DRB CASE NO/PROJECT NO: 1003119

RE: Tract 4-B1, Horne Development Addition/sketch

**DEVELOPMENT REVIEW BOARD
ACTION SHEET**

15. ~~Project# 1003119~~
07DRB-70321 SKETCH PLAT REVIEW
AND COMMENT
- WAYJOHN SURVEYING INC agent(s) for ASN, LLC request(s) the above action(s) for all or a portion of Tract(s) 4-B1, **HORNE DEVELOPMENT ADDITION**, zoned SU-1 PLANNED COMMERCIAL, located on HOTEL CIRCLE NE BETWEEN EUBANK BLVD NE AND TOMASITA ST NE containing approximately 5.0392 acre(s). **THE ABOVE REQUEST WAS REVIEWED AND COMMENTS WERE GIVEN.**

DRAWN: E W K	SCALE: 1" = 50'	FILE NO. SP-11-02-2003
CHECKED: T D J		
DRAWING NO. SP110203.DWG	26 NOV 03	SHEET 2 OF 2

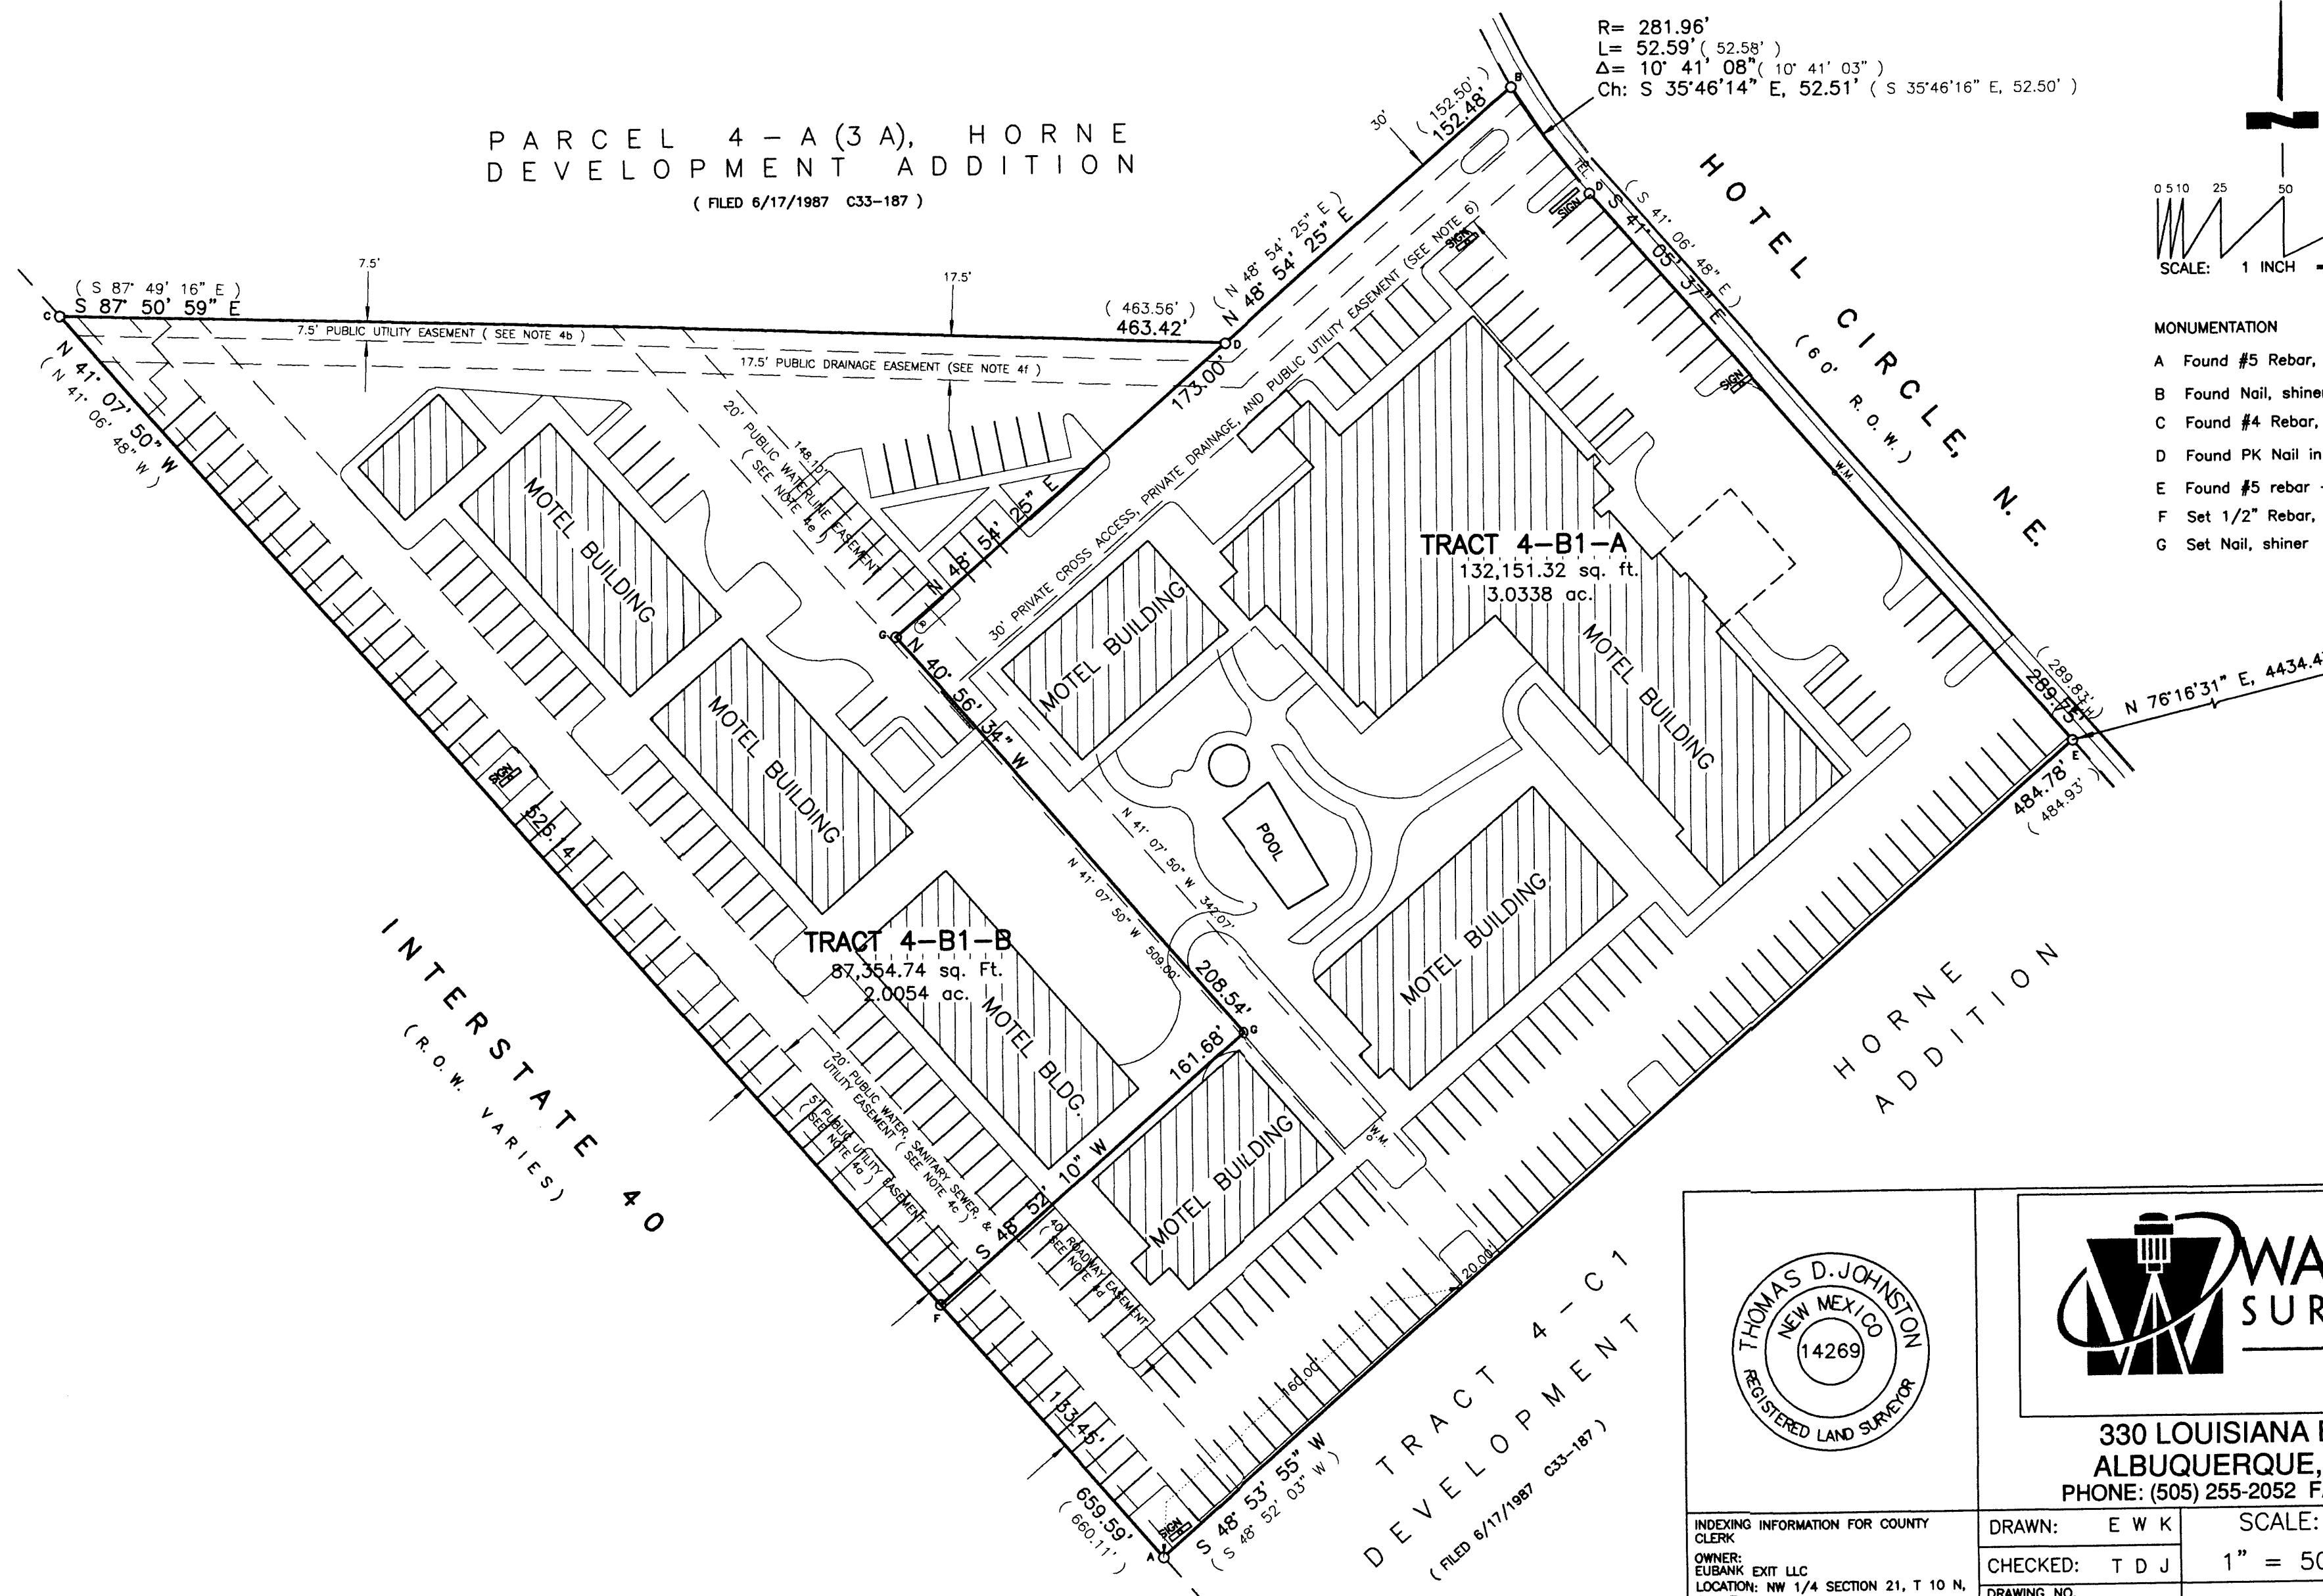
1. In order to subdivide, separate water and sanitary sewer accounts must be established for the additional lot.
2. New lot must have a separate sewer connection to the public main line or have a legal agreement with the other property.
3. Plat must show all adjacent easements, there is an existing public sanitary sewer line along the north property line.
4. A tapping permit for sewer service will not be issued until the Fire Marshall has approved the overall fire protection plan for both lots.
